WEST SUSSEX COUNTY COUNCIL CONSULTATION

TO:	<u>Arun</u> District Council <u>FAO:</u> Simon Davis
FROM:	<u>WSCC</u> - Highways Authority: Tim Townsend
DATE:	16th July 2019
LOCATION:	Cinders Lane Nursery & works to R/O Cinders Lane <u>Yapton</u> <u>BN18 0JJ</u>
SUBJECT:	<u>Y/4/19/RES</u> Approval of reserved matters following outline consent Y/5/17/OUT for 51 No. dwellings. This application affects a Public Right of Way. <u>More information received.</u>
DATE OF SITE VISIT:	
RECOMMENDATION:	Advice / Modification
<u>S106</u> CONTRIBUTION TOTAL:	£ SEE PREVIOUS S106 AGREEMENT ATTACHED TO OUTLINE CONSENT.

This is the second WSCC County Highways (CHA) response to the planning application for approval of reserved matters following outline consent Y/5/17/OUT for 51 No. dwellings and follows submission of replies to the previous WSCC CHA response of 25th June 2019 from the applicant's planning agent (Matthew Utting to Simon Davis dated 5th July 2019).

PLOTS 21-24 | PLANS AND ELEVATIONS
DEVELOPMENT AT:
CINDERS LANE
YAPTON
BN18 0JJ
FOR
CRAYFERN HOMES LIMITED

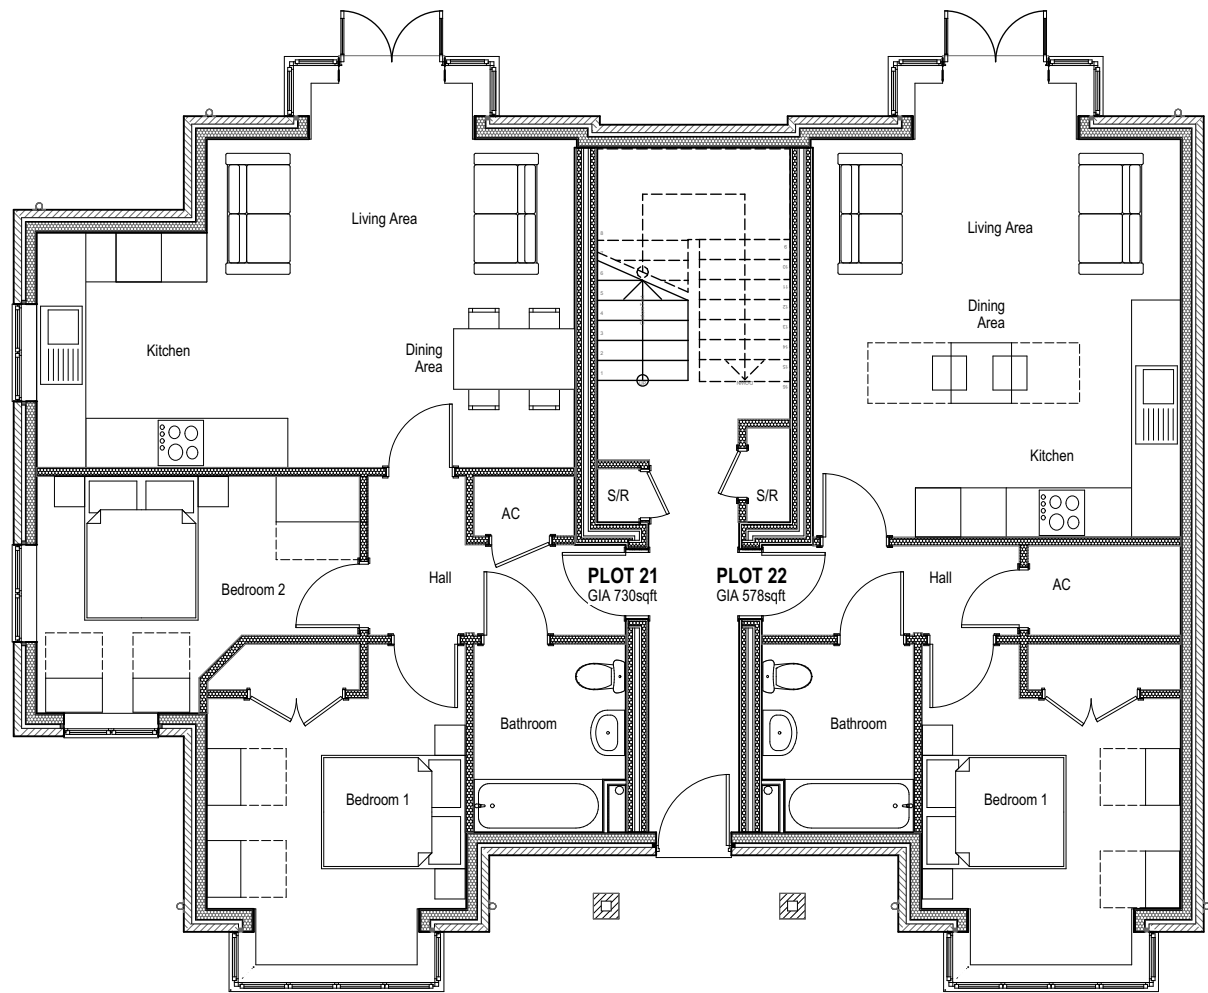
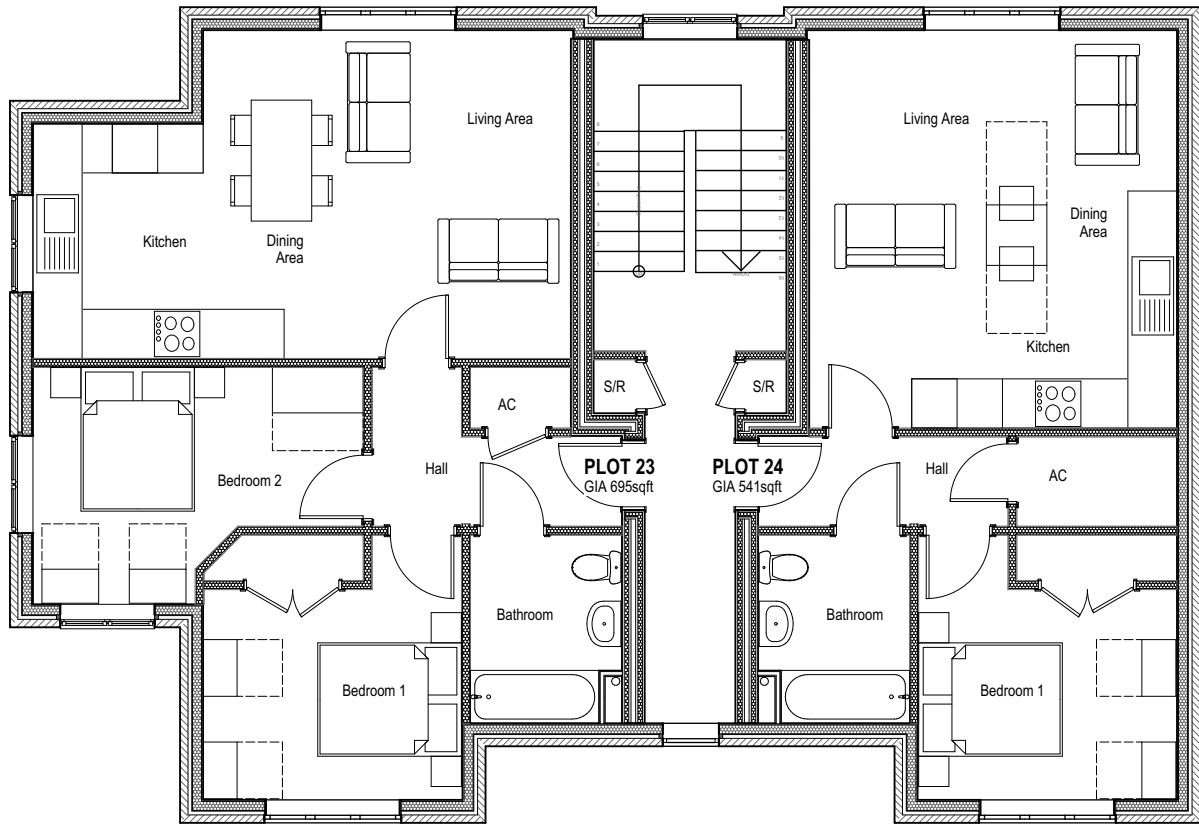
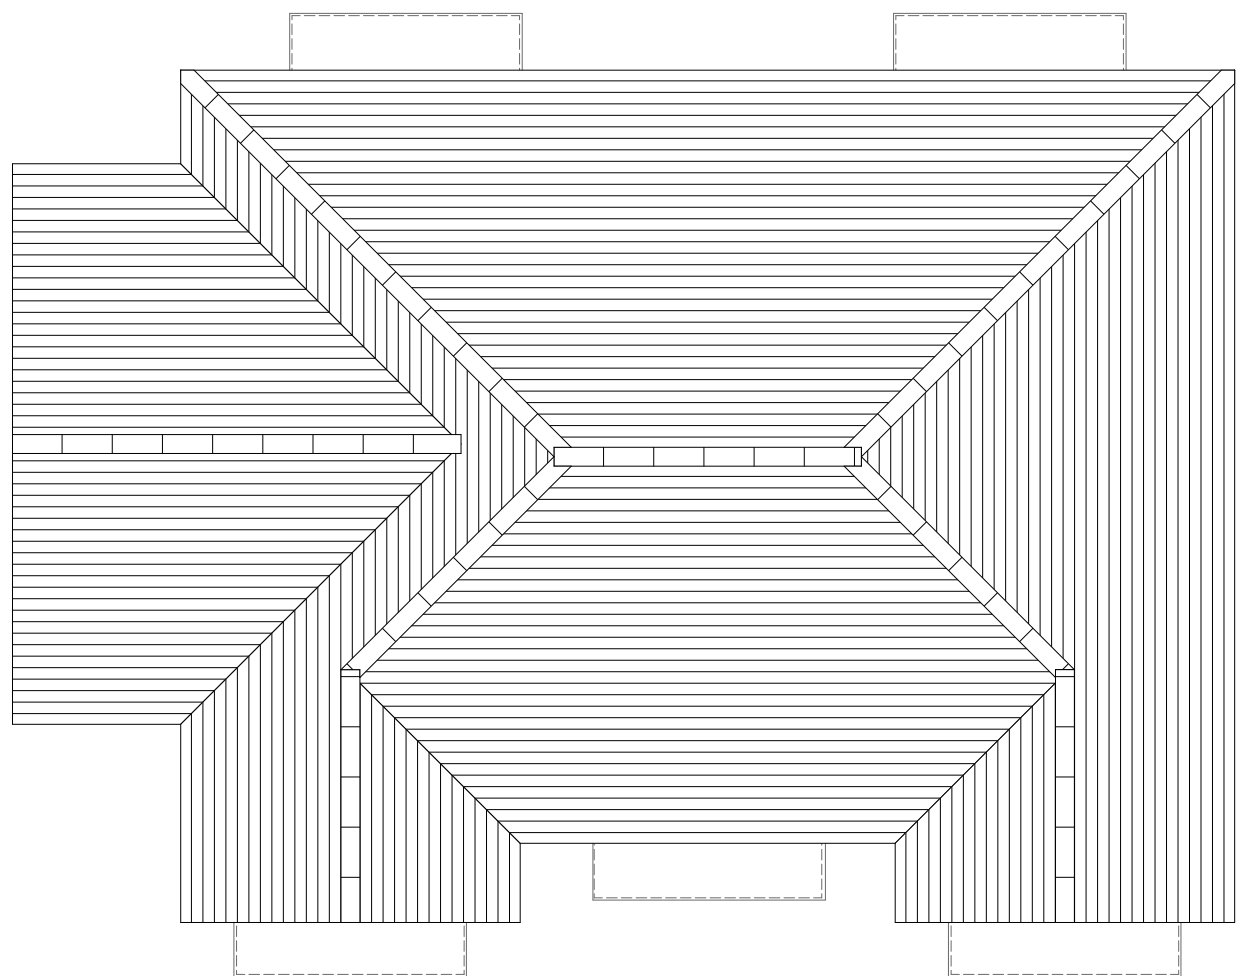
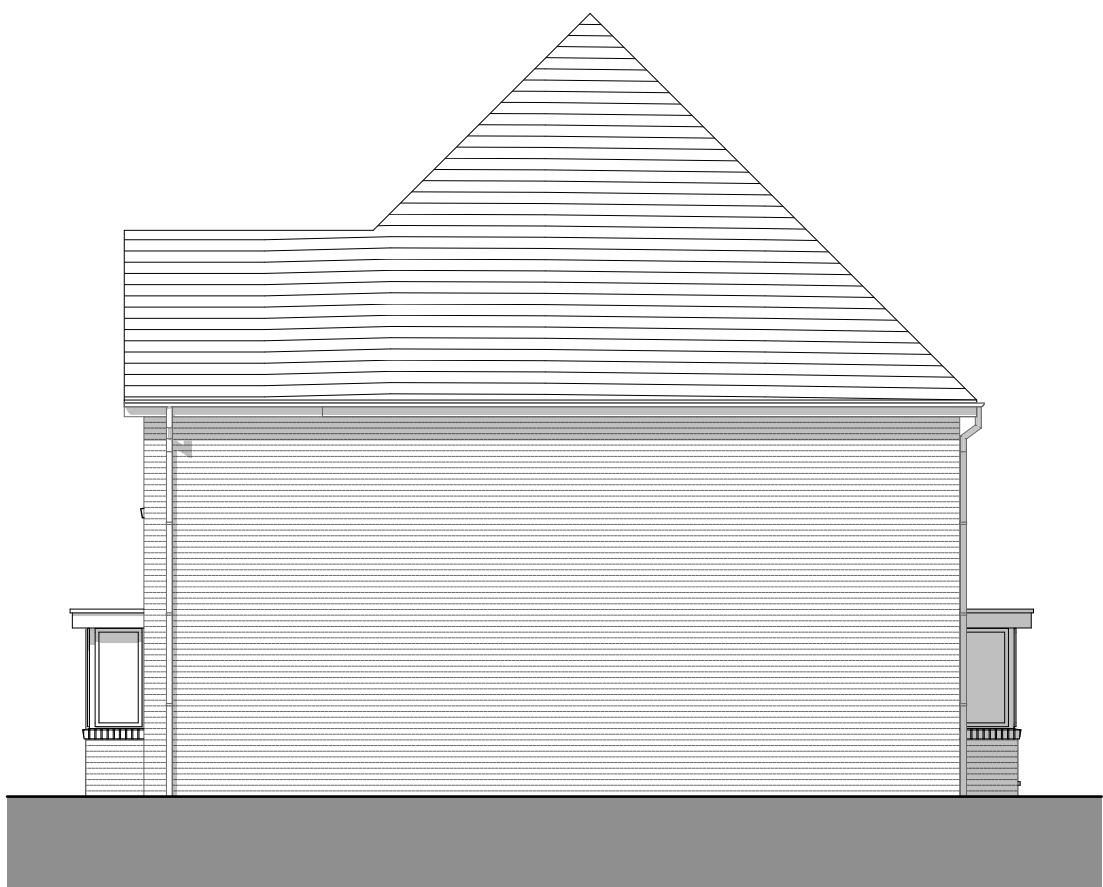
Parking spaces to the front of plots 21-26, 27 and 39-46 have been increased to a length of 5.5m. *Noted.*
